Our Ref: BS/2205771/RM1Update

**Land at Ford Airfield, Ford, Arun
Proposed updates to RM1 (north) - (application ref: F/15/24/RES)**

This letter sets out where changes to the scheme as a result of updates to the layout following consultee comments can be found in the Transport Technical Note (Ardent ref 2205771-R12F) and details specific outstanding comments contained within consultee responses. Further liaison has been undertaken between ACE and WSCC to confirm the detail of the response and agree the changes that have now been adopted into the layout and as summarised in this letter. In considering the comments received and updating the layouts to suit, the amendments are supported by revised versions of ACE Drawings 2205771-002 and 003.

HT341_3B4P
88.0 SQM / 948 SQFT

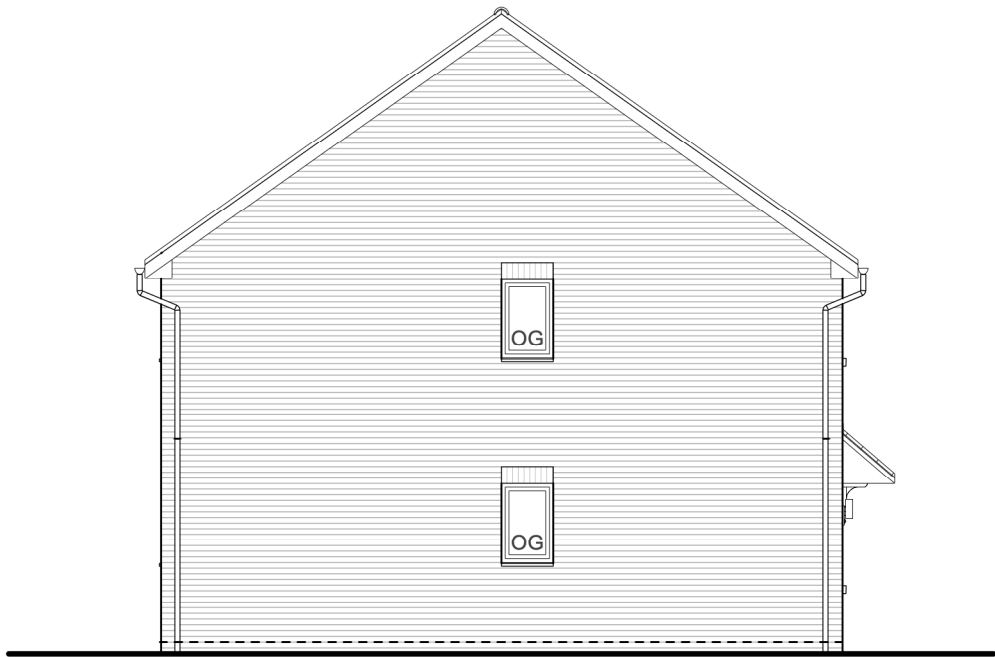
The proposed EV charging points for 176 and 177 remain in an area that is likely to be offered for adoption.

No charging points are located within areas to be offered for adoption.
